Subject: RE: *EXTERNAL: Barratt Temp Sales Office Applications (Y/31/21/PL & Y/32/21/A), Land at Drove lane, Yapton

I write to alert you that it is our intention to refuse these two applications on the grounds of visual harm to the nearby heritage assets and to the character of the area/streetscene. You may also have noted on the application files the comments of our Conservation Officer and the Parish Council. I also consider that the amount of freestanding adverts/signs in the temporary area is excessive in such a sensitive location.

Barratt Static Banner
Barratt Logo
Flags - 600mm x 2200mm

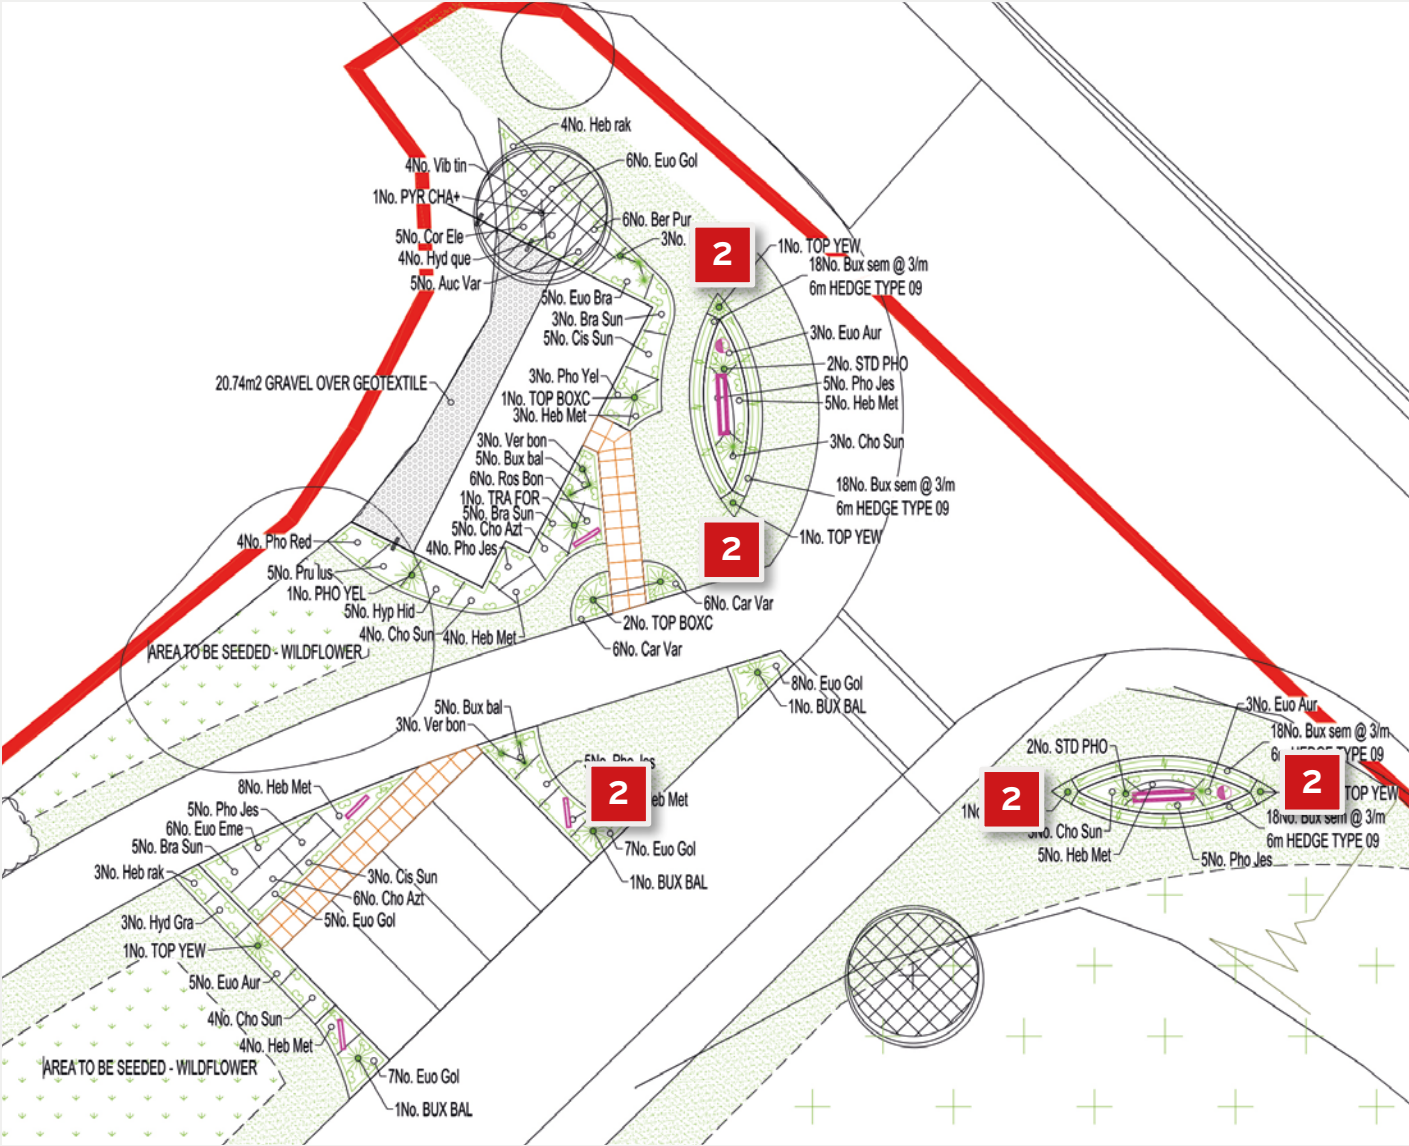
I don't believe that the Parish have just asked for a reduction in flags. Their comment is actually that the flags and freestanding sign should be sufficient which implies that they are objecting to all the other signage).

The Parish Council have commented that the proposed advertising is appropriate (albeit with reduction in flags which is entirely doable) but are concerned about the prominence of the sales cabin and would prefer this located within the main body of the site. We understand this comment but it is not feasible because the main site will be under construction, hence the request for a temporary sales cabin at the front of the site.

It appears that the main concern of both the Conservation Officer, Yapton Parish Council and Arun DC centres around the proposed timeframe and temporary nature of the application. We are happy to discuss this and impose a timeframe, including agreeing a condition setting out the timeframe if that would provide the necessary reassurance.

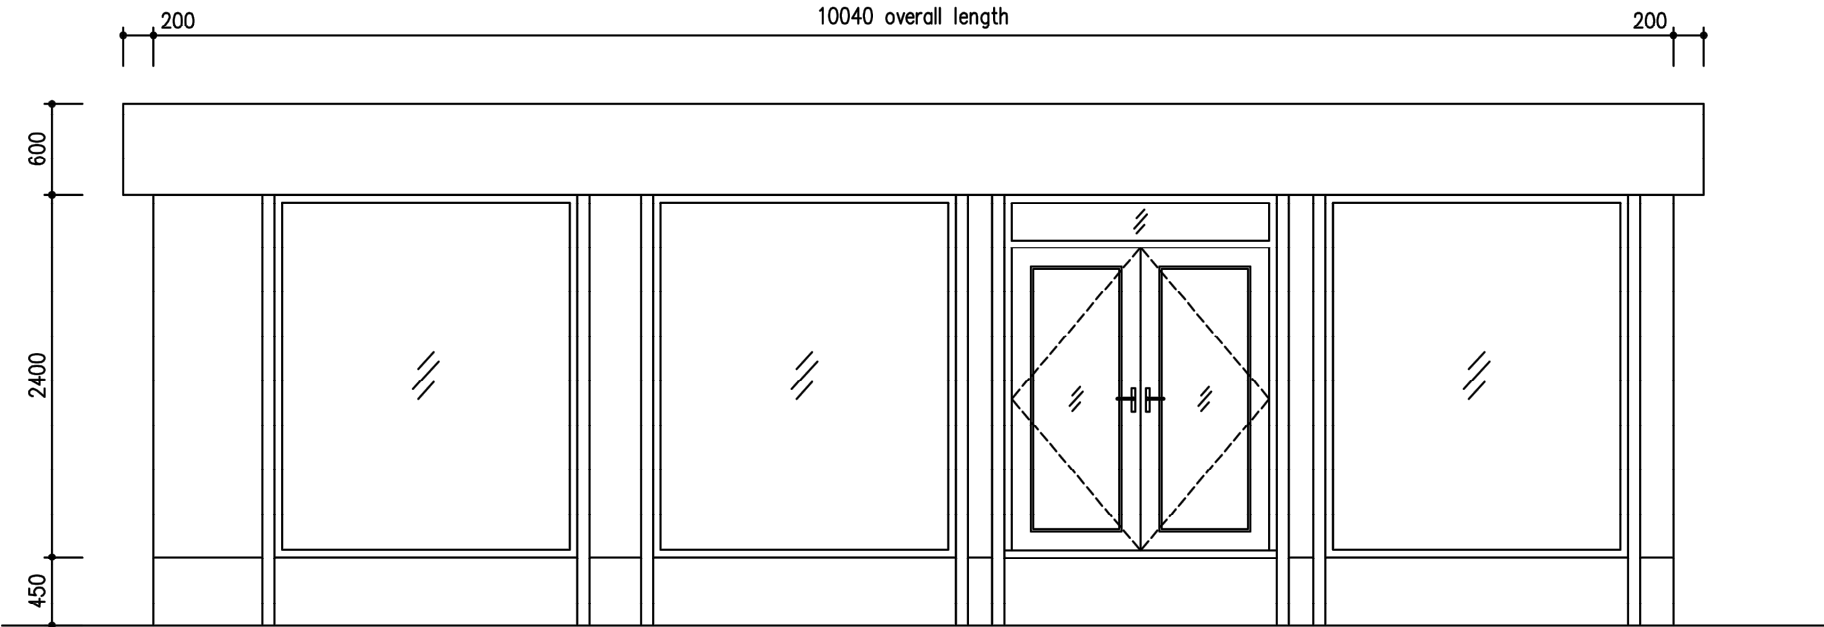
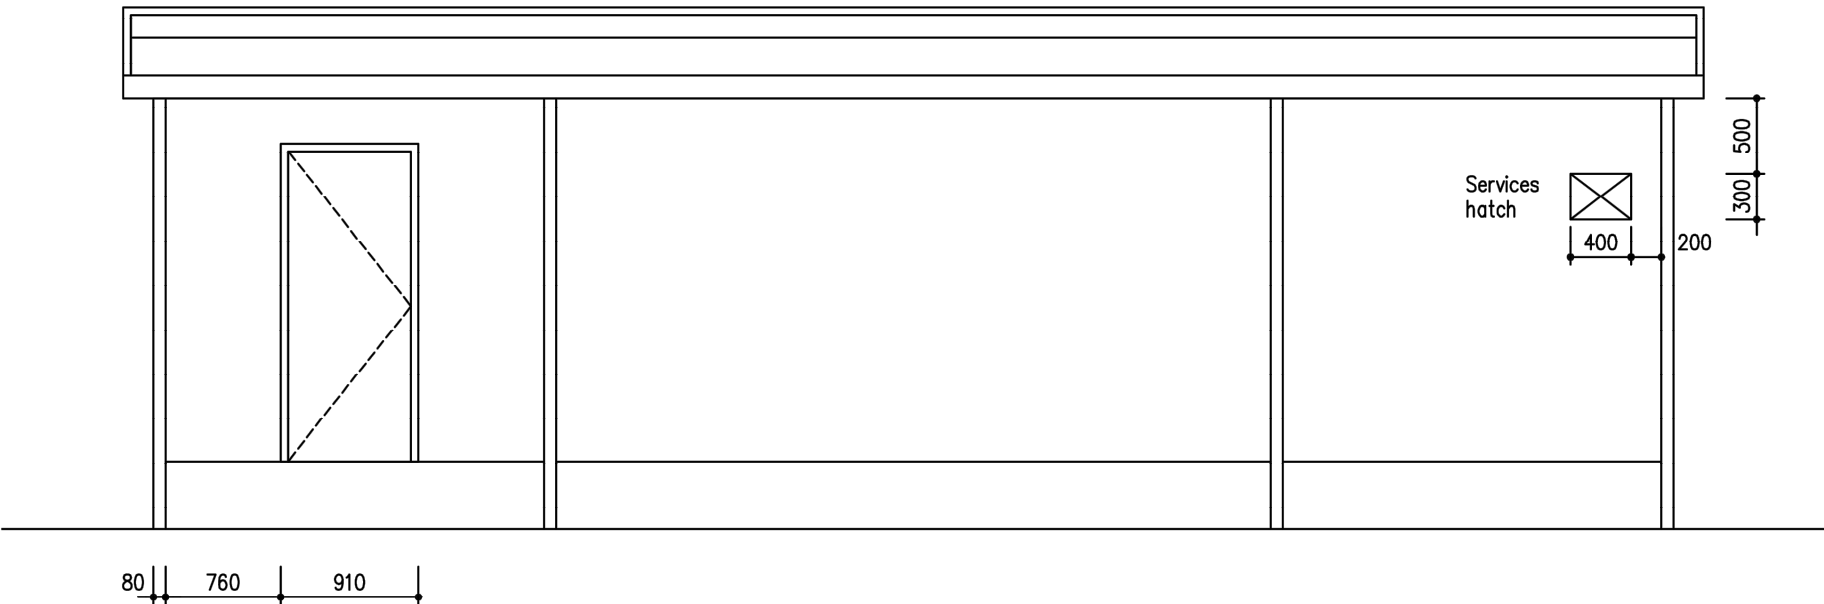
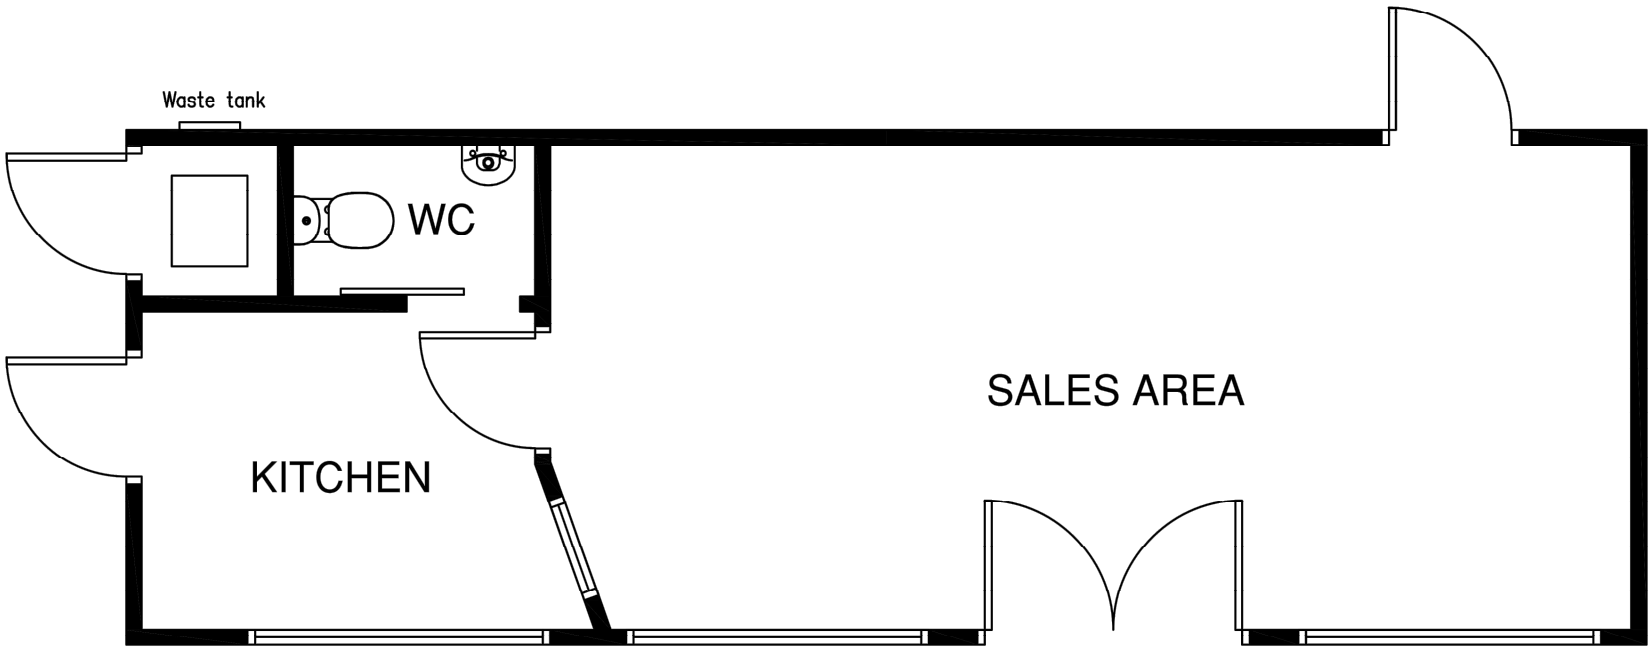
The Conservation Officer is aware of the wider context/the approved outline planning permission. However, as you can see he has concluded *less than substantial harm* and in order to resolve this, it would be necessary to demonstrate the public benefits of the proposed cabin. We would not be able to consider the benefits of the 300 houses in this determination and we can't consider private benefits. On this basis, I do not consider that this harm can be resolved.

Could you not relocate the temp sales cabin into the site such as in the locations on the attached I have suggested with the red star? There may be other areas within the site where it could go without affecting construction. If you are willing to look at such other options by withdrawing and engaging with me before a resubmission then I believe that we can come up with a solution that is mutually acceptable.
